August 25, 2023

RE: Technical Review #1 – Response to Comments (SP23-003)

Re: SP23-003, "Hidden Valley PRD", Technical Review 1
Location: 12527 51st Ave NE

**PRELIMINARY SHORT PLAT &
PLANNED RESIDENTIAL DEVELOPMENT
FOR
HIDDEN VALLEY**

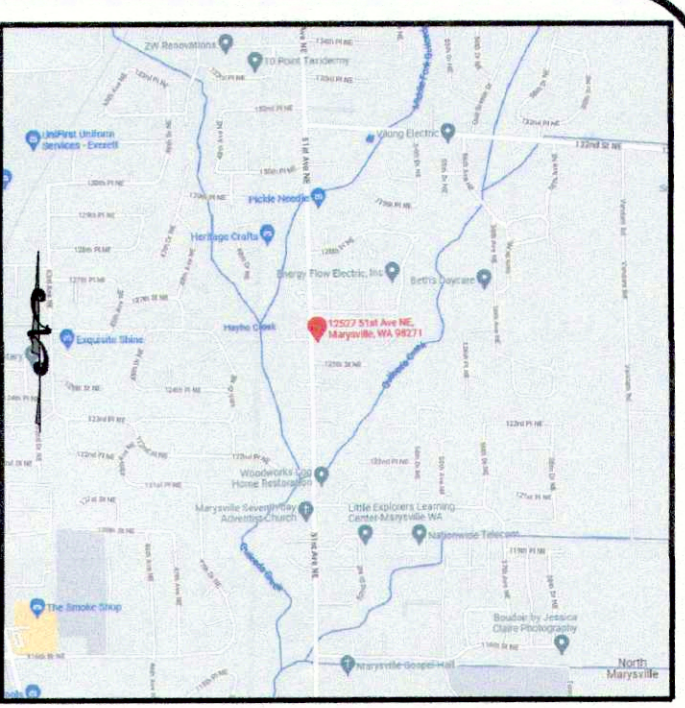
- ✓ 3. From the preliminary site plan, remove the footnotes "If not lot line between homes 10' separation between structures" and "If no lot line between homes 20' separation between structures", as these comments are not applicable to this subdivision. **Removed**

- ✓ 7. The open space to be observable by the neighborhood residents must be centrally located within the project, *and abut a neighborhood street*. The proposed open space will be walled off, invisible and create a safety hazards and a policing problem for criminal activity and shall not be allowed as proposed.

- ✓ 8. Consider placing the open space and the temporary turn-around in the place of lot 3. Lots 1 and 2 may be able to be re-oriented toward 51st Ave NE with access from an auto-court/temporary turn-around from the rear.

ROAD & GRADING

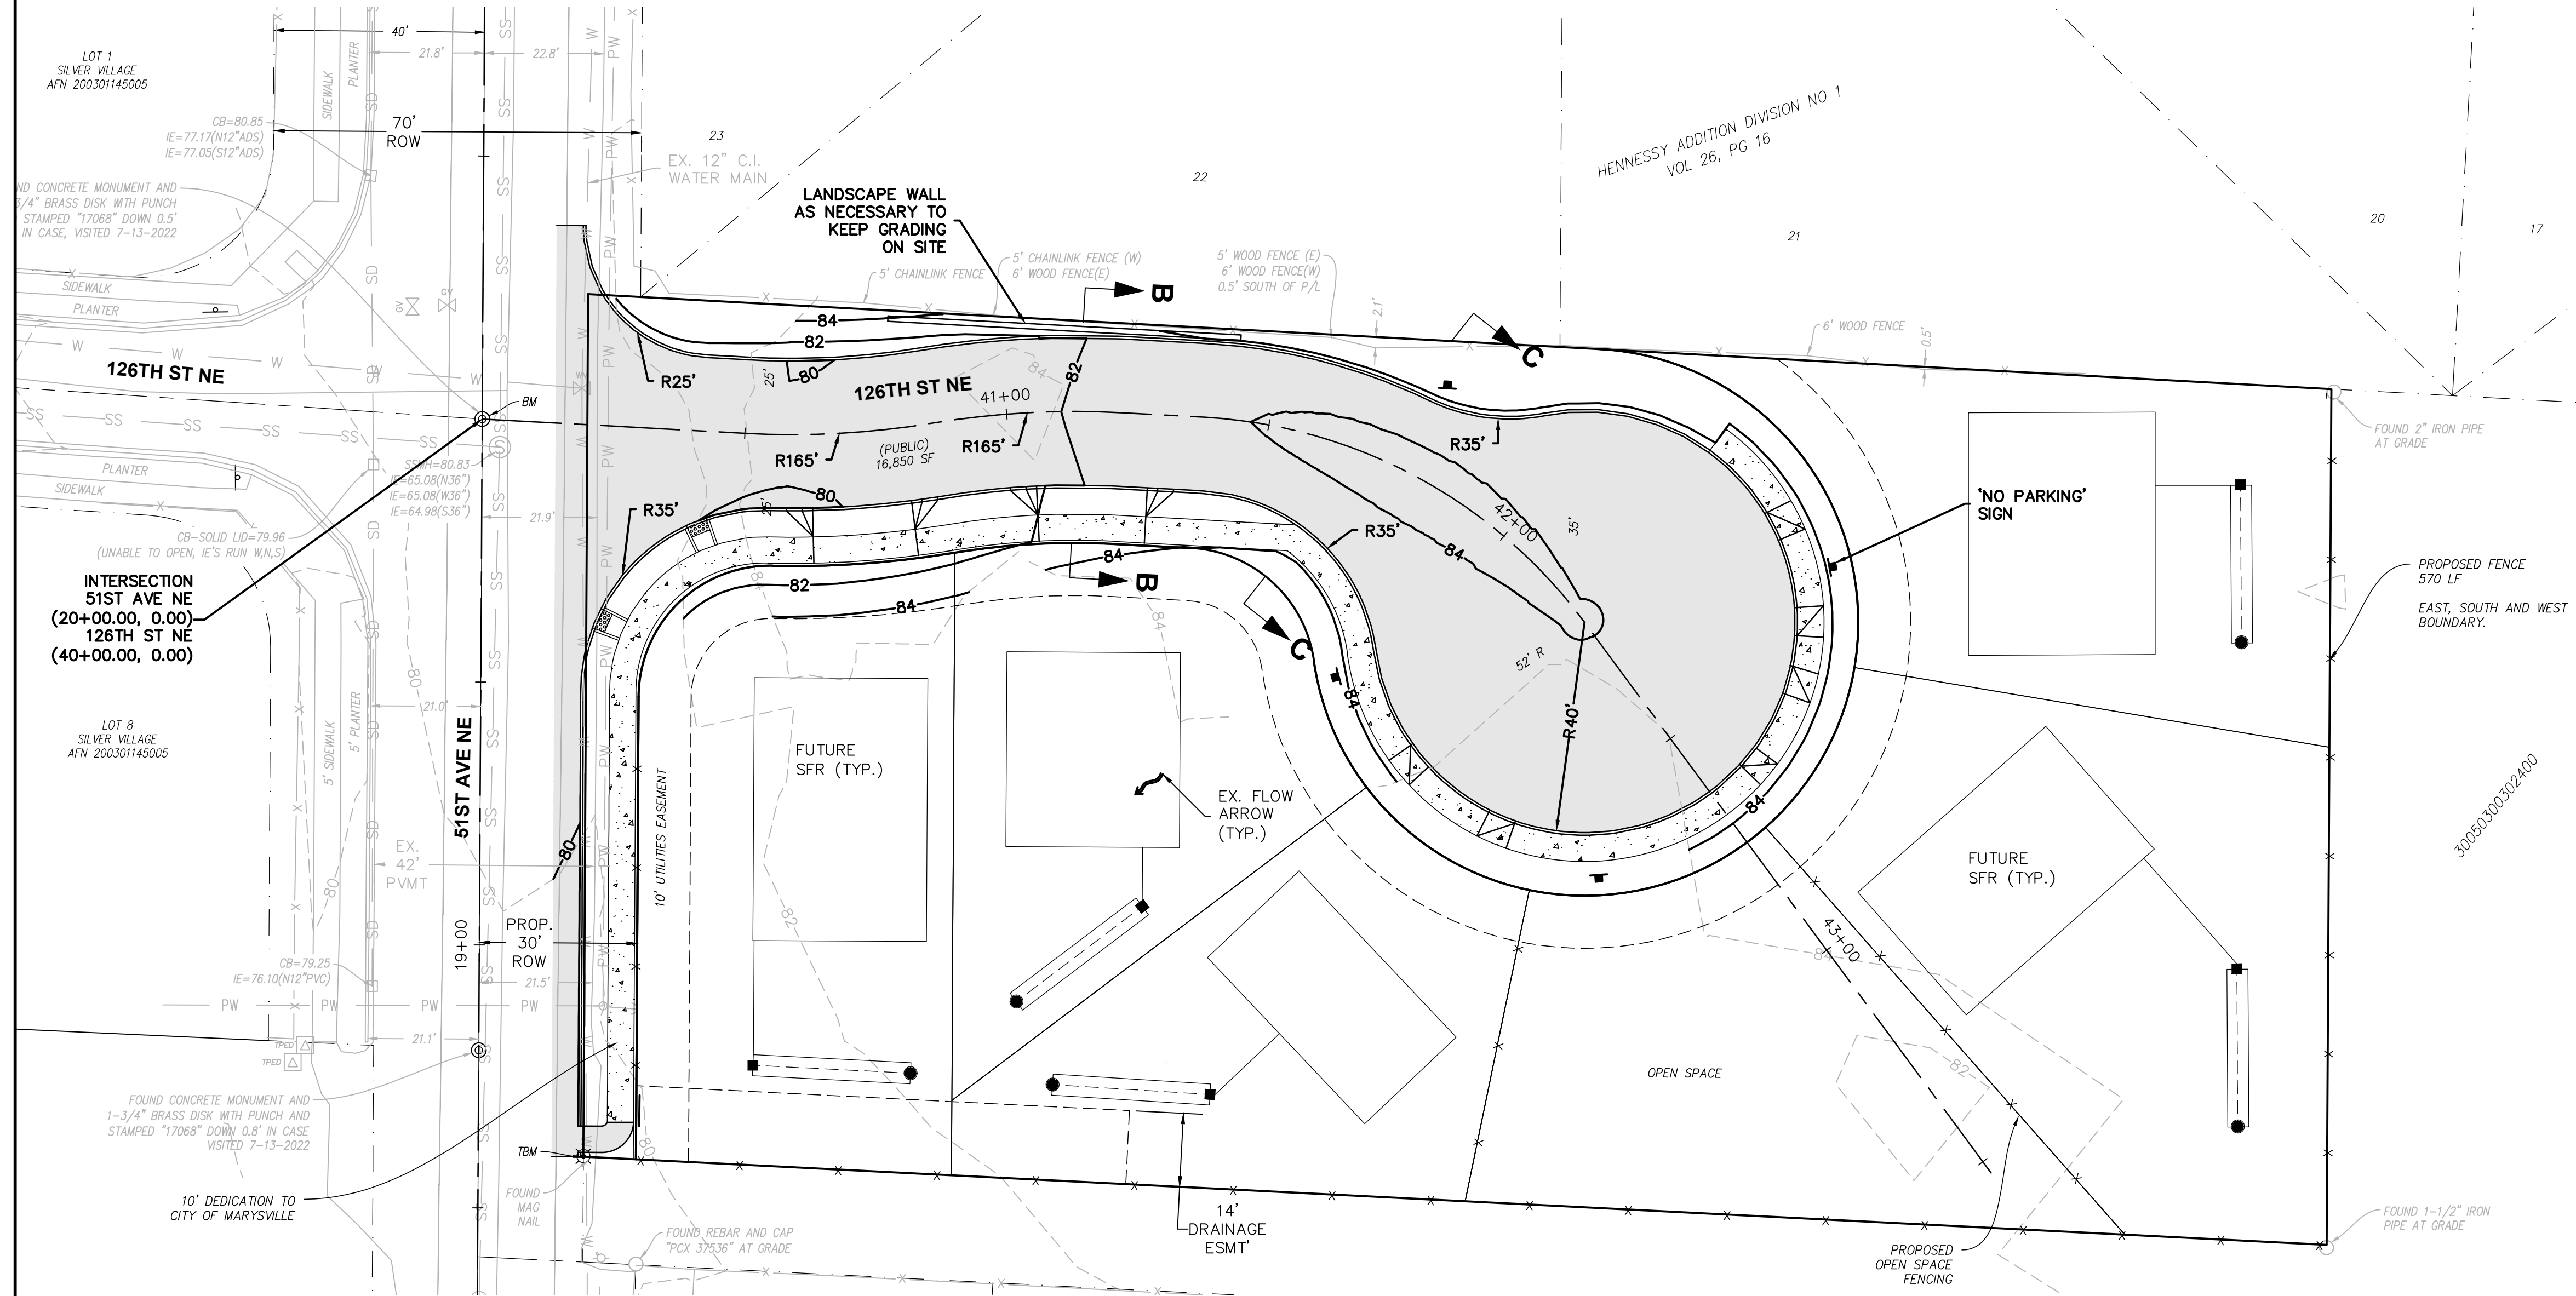
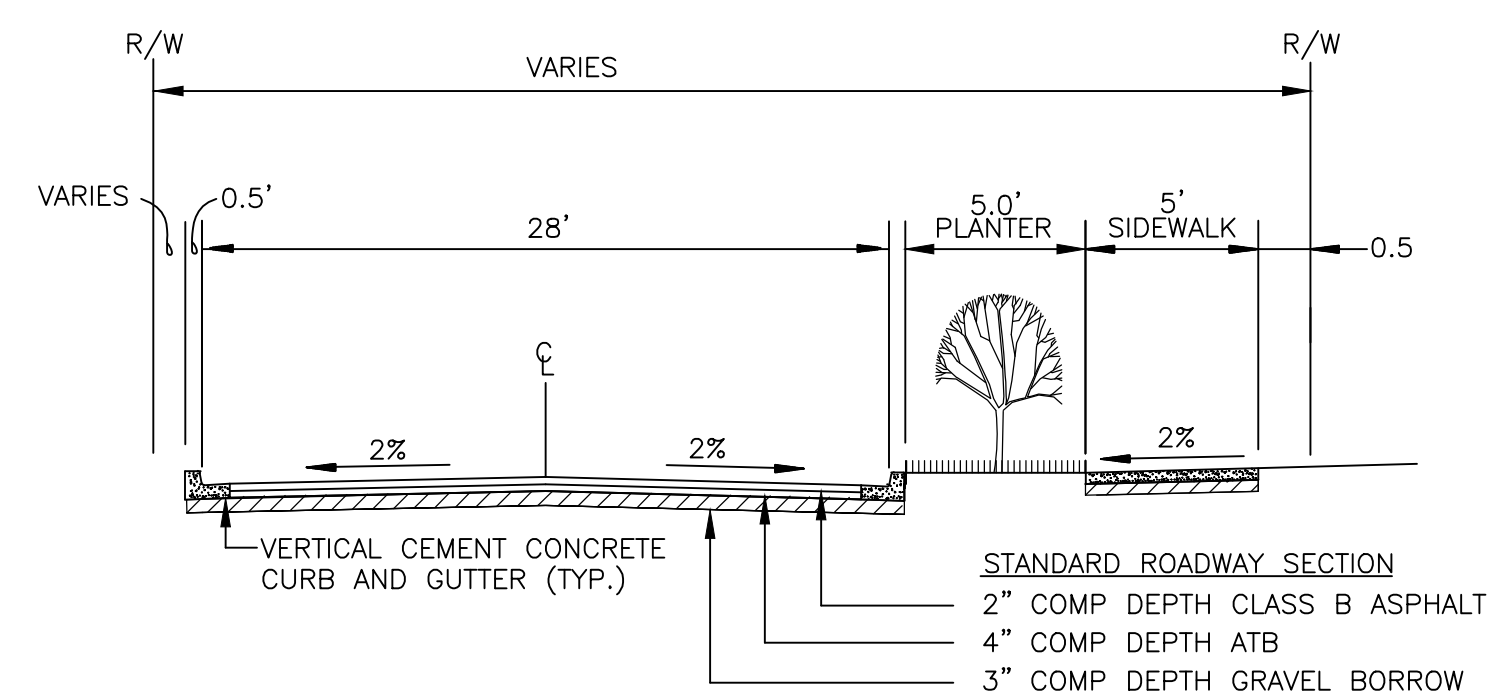
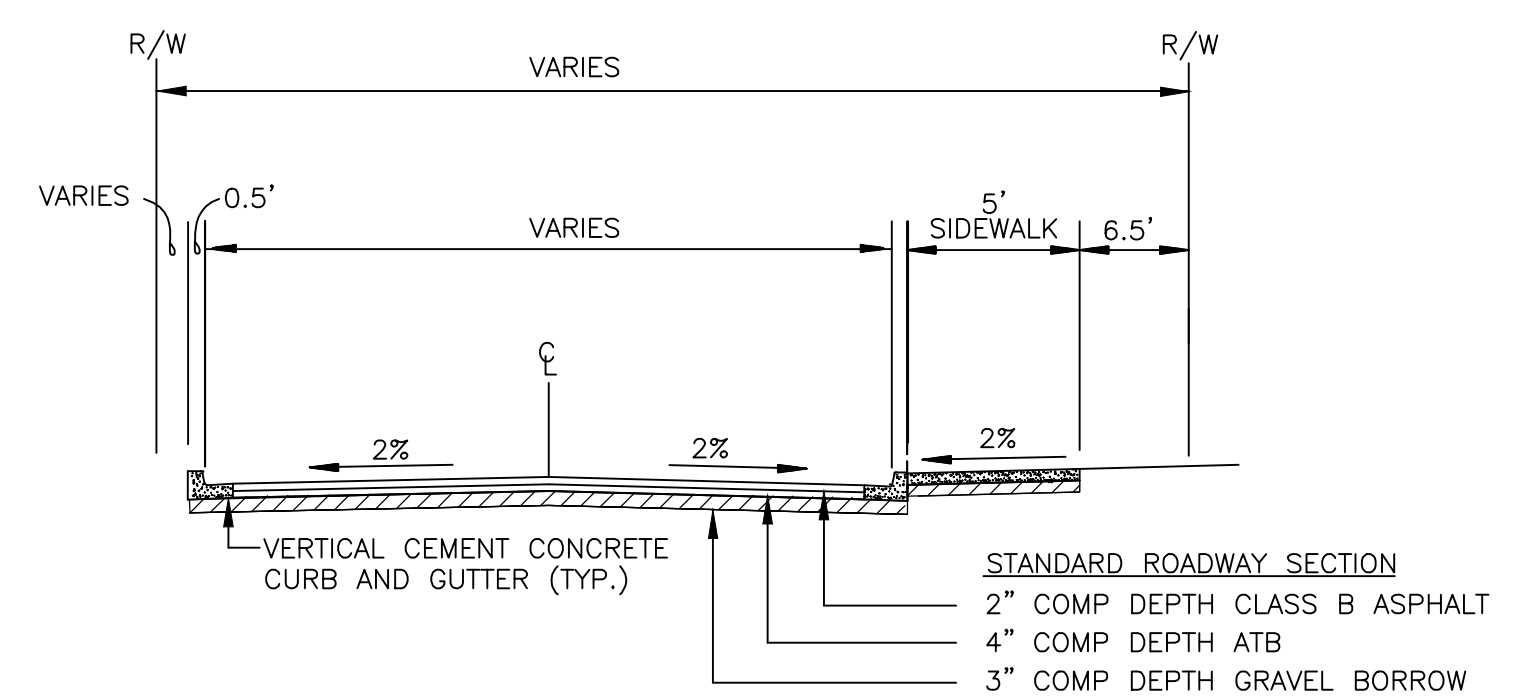
- ✓ 4. Amend the Civil and Landscape plans to show the individual driveways.
- ✓ 5. Amend the Civil Plans to show the 10-foot BSBL as well as the 20-foot driveways setback.

1. The application number has been added to each sheet of the revised civil plans.
4. The civil plans have been amended to show the individual driveway cuts.
5. The civil plans have been amended to show the 10' BSBLs along with the 20' garage setbacks.
